MODIFICATION REQUEST:
Pacific Pines Estate, Lennox Head –
Modification to Concept Plan and Project
Approvals
(07_0026 Mod 2)

Director-General's
Environmental Assessment Report
Section 75W of the
Environmental Planning and Assessment Act 1979

June 2011

**REMOVAL AND RETENTION OF HAIRY JOINT GRASS ASSOCIATED  
WITH AMENDED CONCEPT PLAN**

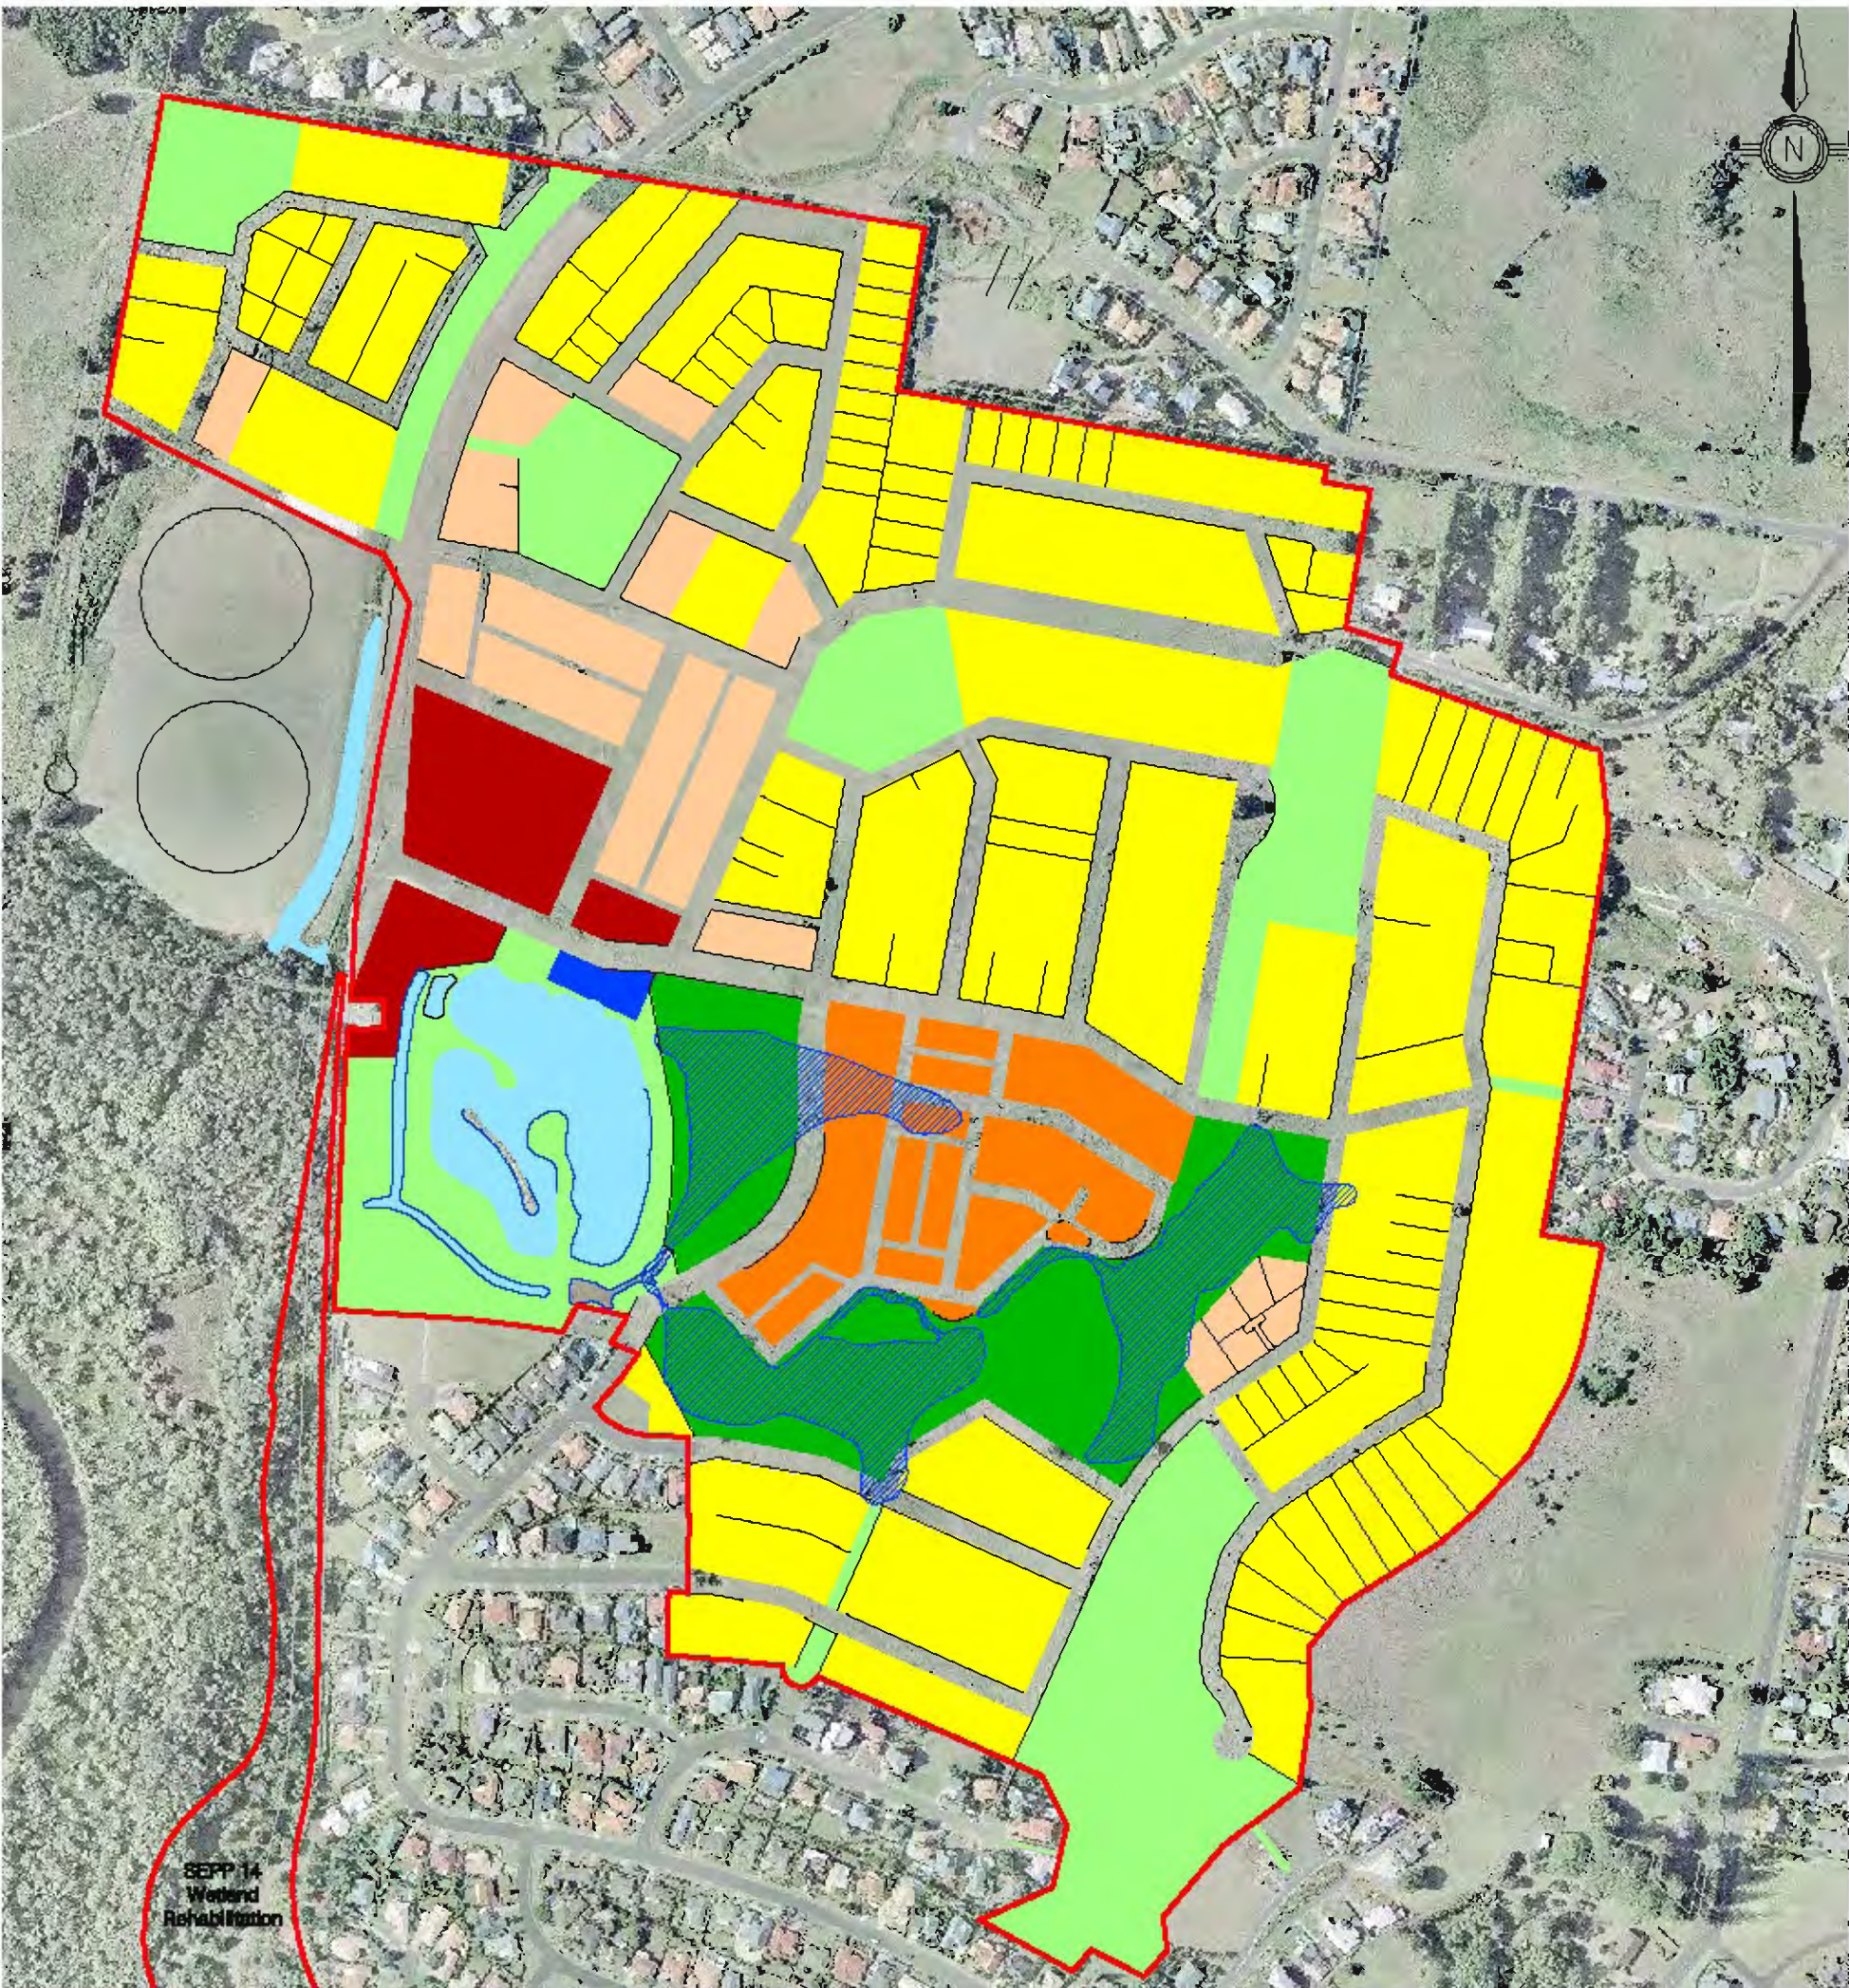
- raised concern with the proposed method of on-site mitigation for increasing Freshwater Wetland EEC habitat by altering the existing surface level of part of the conservation zone and the translocation of Hairy Joint Grass and Square Stemmed Spike Rush due to the uncertainty of their success and unknown impacts. Council did, however, support the increased area of conservation area proposed to be provided on site.

- raised concern that the mapping of Hairy Joint Grass and Square Stemmed Spike Rush is incorrect;
- identified a number of other conditions that would need to be modified as a result of the proposed modification;

- provided photographs to show inaccuracies in the proponent's mapping of threatened species;
- raised concern with the proponent's classification of Freshwater Wetland EEC;

The Department shares the concerns over the viability of translocation, however, accepts that this is just one tool available to the proponent to mitigate impacts on the threatened species populations within the site. Nevertheless, to address the agency and Department concerns, a condition is recommended that clarifies that no translocation of threatened species into the conservation zone can occur unless it has first been approved through the Conservation Zone Management Plan (CZMP).

**AREAS OF POTENTIAL ADDITIONAL HAIRY JOINT GRASS IN  
CONSERVATION ZONE**

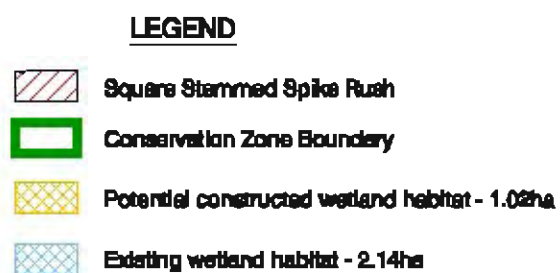
The proponent's EIAMS identifies land within the site that does not currently support wetland habitat due largely to its higher elevation. It notes, however, that with some earthworks, these areas could be lowered and active revegetation undertaken to merge these constructed wetlands with the adjoining natural wetlands. The EIAMS only identifies indicative locations and no details such as quantity of earthworks has been provided at this time.

Both Council and the then DECCW have raised concern with the viability of such works. In particular, Council notes that some of the areas identified by the proponent for future artificial wetlands would require alteration to the surface level of the land by up to two metres, the impacts of which are unknown.

The Department is unable to confirm Council's assertions but recognises that there is a degree of uncertainty regarding the appropriateness of landforming as a way in which to compensate for the loss of threatened species, particularly where this may be at the expense of recovering other threatened species that may be more suited to the existing site conditions.

Accordingly, the Department recommends a condition be imposed that clarifies that no habitat modification, such as through landforming in the conservation zone is permitted unless it has first been approved through the Conservation Zone Management Plan.

Network Option 5

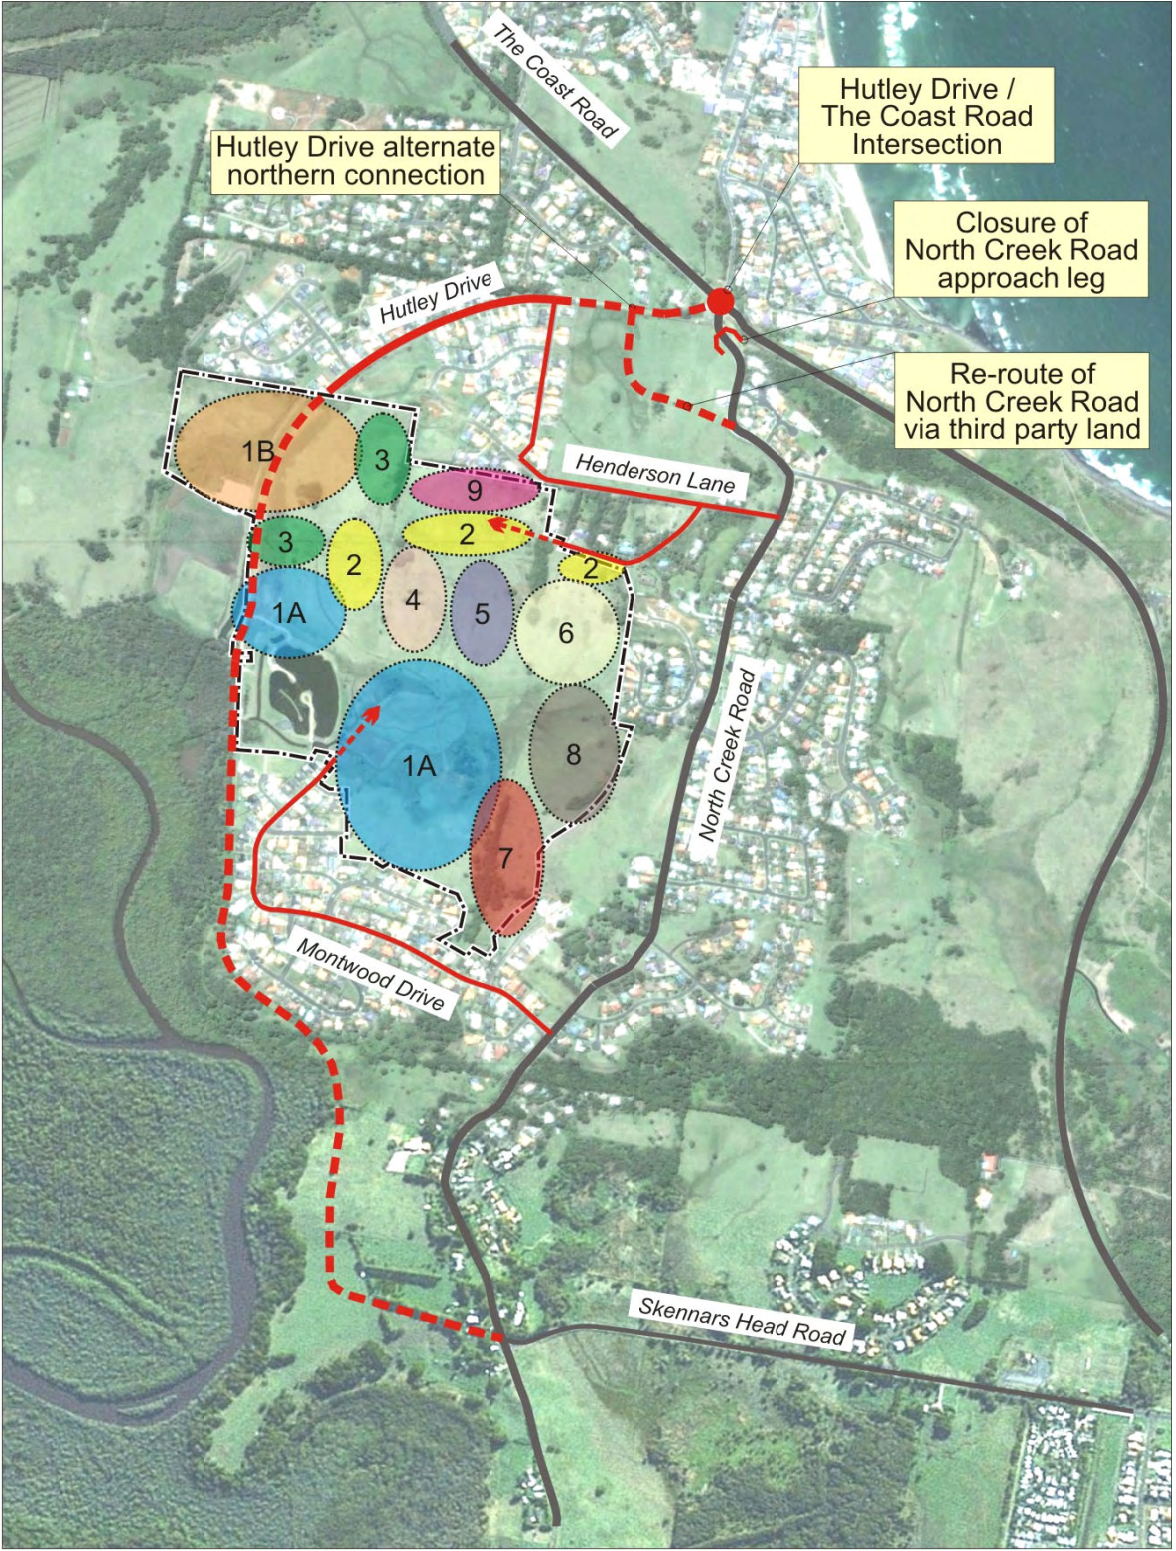
- identifies that Option 5 of the traffic report is Council's preferred option for the development of Stages 6-9; and
- provides further information on the timing and revisions to the draft LEP to better align with the existing approval.
